Online Comment

Application H08-0260-25
Location 61 HIGH STREET GOSBERTON SPALDING PE11 4NJ
Proposal Removal of existing single storey extensions, replaced with new single storey extensions, garage conversion, internal alterations and covered porch

Name Diane Fairchild
Address Conservation Assistant (Tree Preservation) Planning & Development

Date Submitted 15-04-25
For/Against Comments

SITE PLAN - 1:200

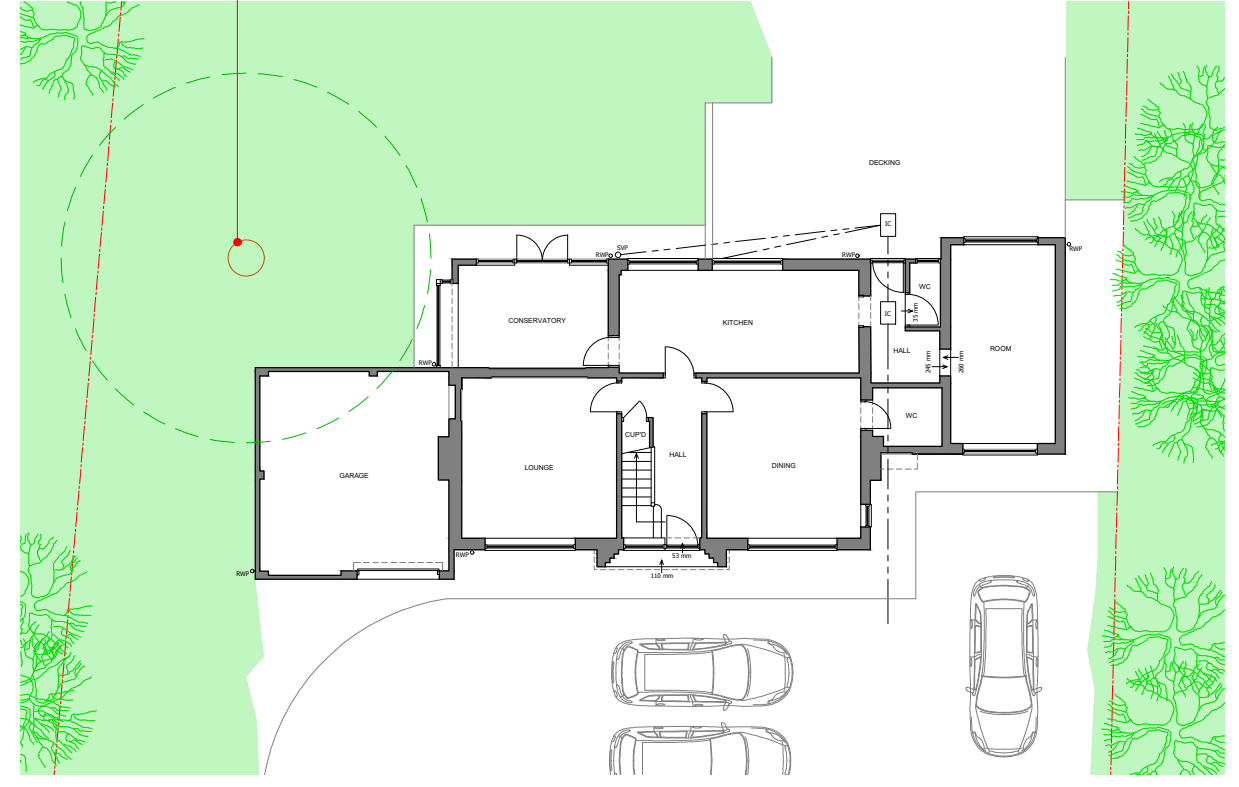
Bearing in mind the close proximity of the protected mature walnut tree, will additional foundations be required for the proposed building construction within its Root Protection Area, or will the existing be sufficient? Obviously the aim is to keep root damage to an absolute minimum, but provide sufficient foundations to prevent any potential future influence by the tree.
